Rampion Two Offshore Wind Farm

Appendix C6 to the Natural England Deadline 6 Submission

Natural England's Advice on Marine Mammals

01 August 2024

Figure 11.3 Marine mammals noise disturbance contours (extract from SMRU report)

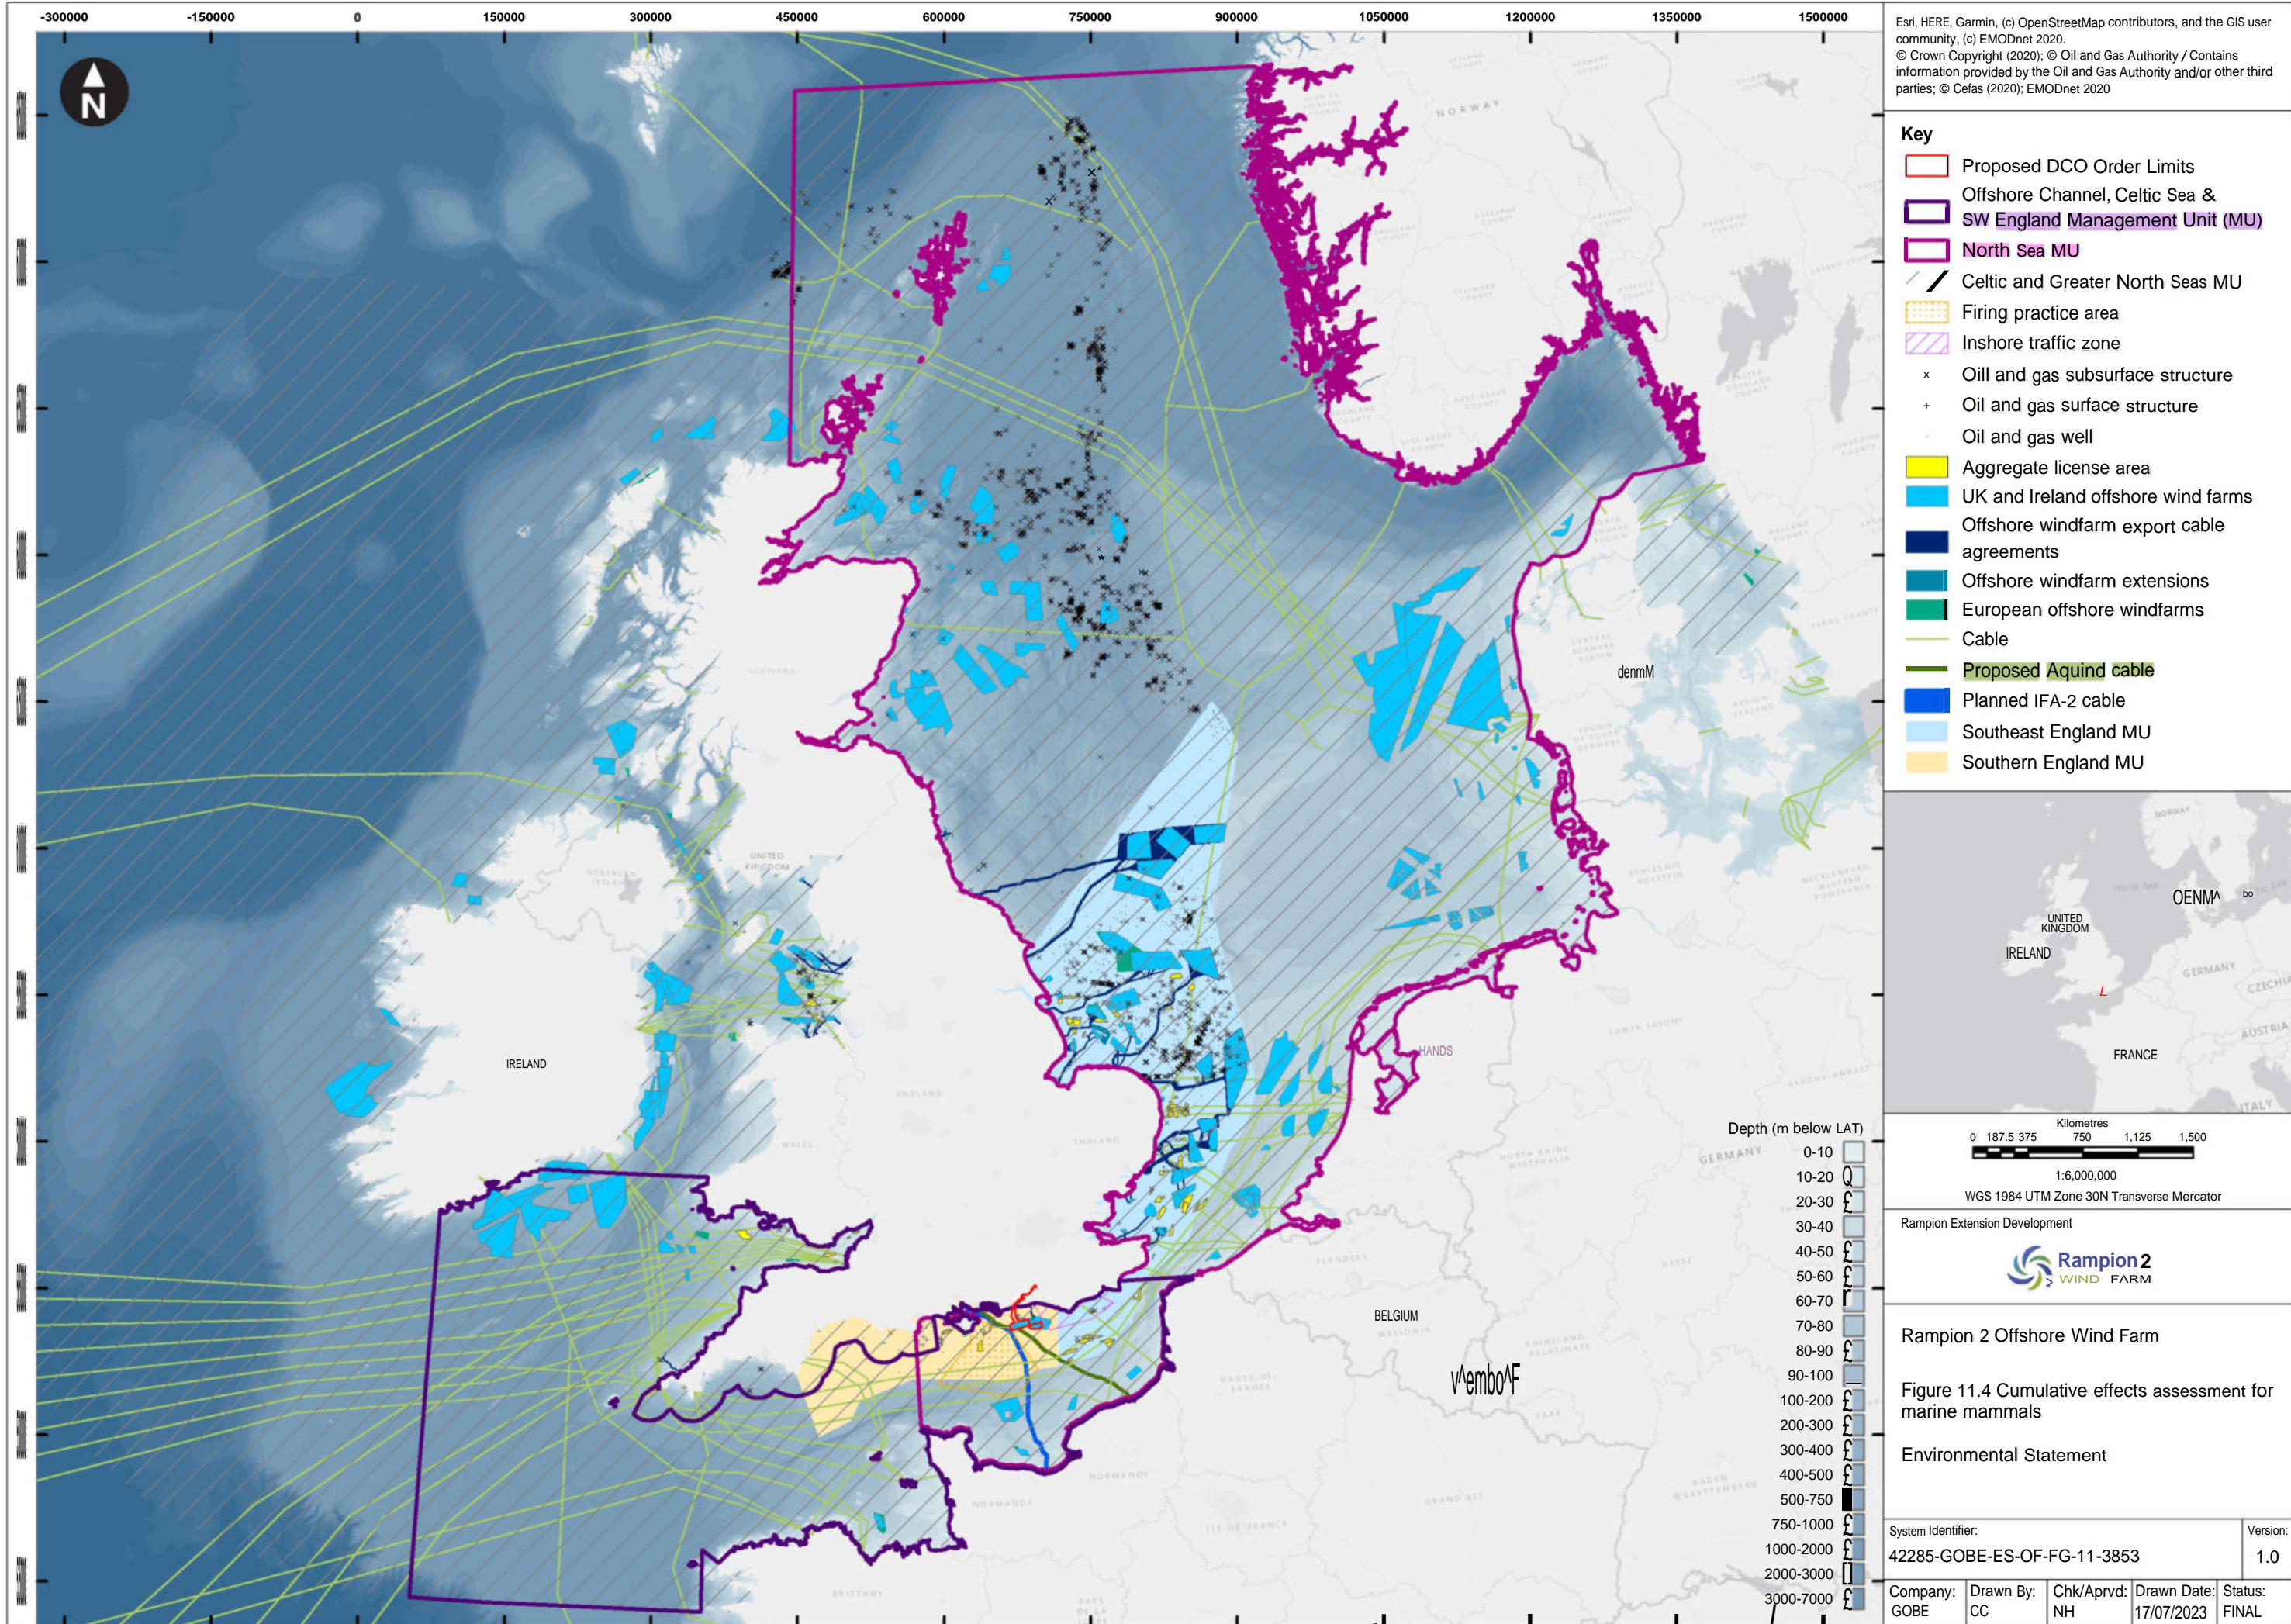
include the reduction in noise from the DBBC in the underwater noise modelling. We advise that the noise reduction offered by the DBBC is included in the refined underwater noise modelling undertaken post-consent.

Natural England is currently reviewing its advice on suitable effective deterrent ranges for different levels of noise reduction offered through noise abatement systems. We do not necessarily agree that the 15km EDR is appropriate in this case, due to a lack of evidence. We advise monitoring of marine mammal disturbance responses to piling with noise abatement systems is considered as part of the post-consent monitoring and would expect to see this in the Offshore Monitoring Plan.
